## DRAINAGE AND TRANSPORTATION INFORMATION SHEET

**Project Title:** 2350 Alamo Road **Building Permit #** \_\_\_\_\_ **Hydrology File #** \_\_\_\_\_

**RE: 2350 ALAMO ROAD SW  
TRAFFIC CIRCULATION LAYOUT  
RESPONSE TO COMMENT**

BIKE RACK

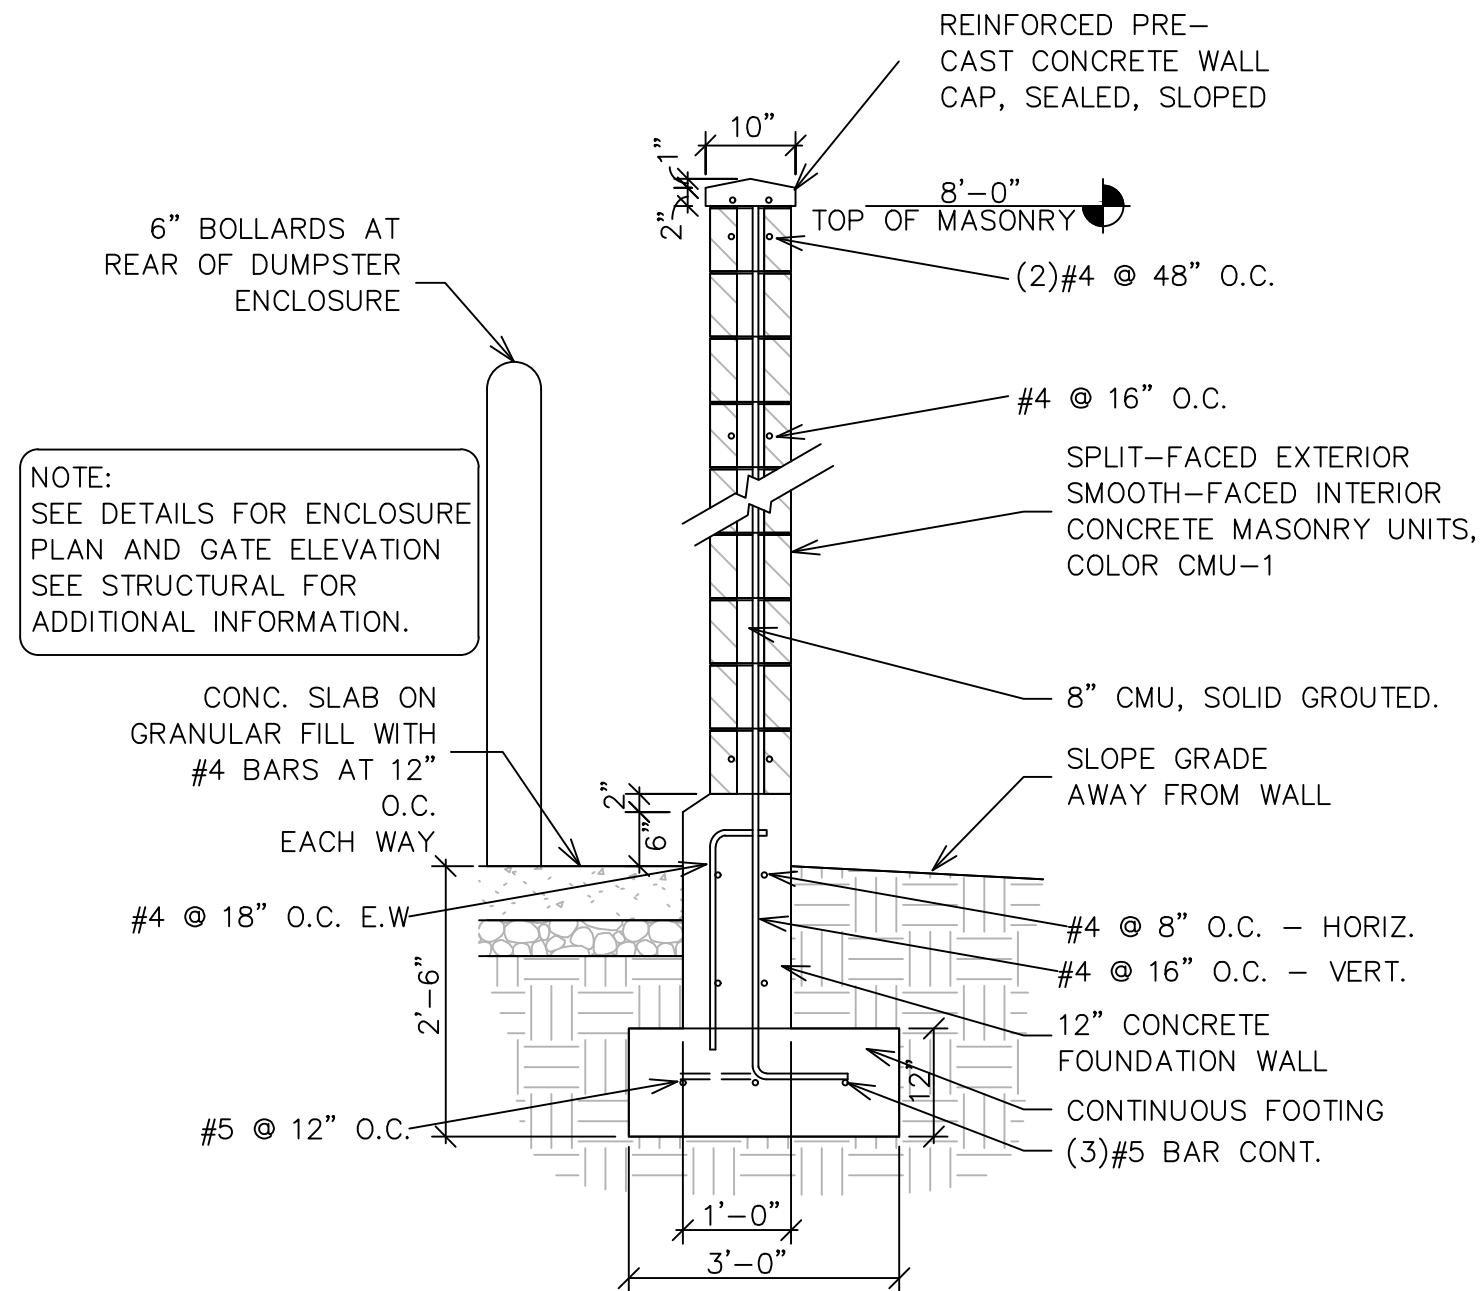
10. Please provide Bike Rack details.

11. All bicycle racks shall be designed according to the following guidelines:

- a. The rack shall be a minimum 30 inches tall and 18 inches wide.
- b. The bicycle frame shall be supported horizontally at two or more places. Comb/toaster racks are not allowed.
- c. The rack shall be designed to support the bicycle in an upright position. See the IDO for additional information.
- d. The rack allows varying bicycle frame sizes and styles to be attached.
- e. The user is not required to lift the bicycle onto the bicycle rack.
- f. Each bicycle parking space is accessible without moving another bicycle.

12. Bicycle racks shall be sturdy and anchored to a concrete pad.

13. A 1-foot clear zone around the bicycle parking stall shall be provided.

14. Bicycle parking spaces shall be at least 6 feet long and 2 feet wide.

**Response: See detail sheet C2.2.**

**Response: See detail sheet C2.2.**

**Response: See detail sheet C2.2.**

**Response: See detail sheet C2.2.**

**Response: See detail sheet C2.2.**
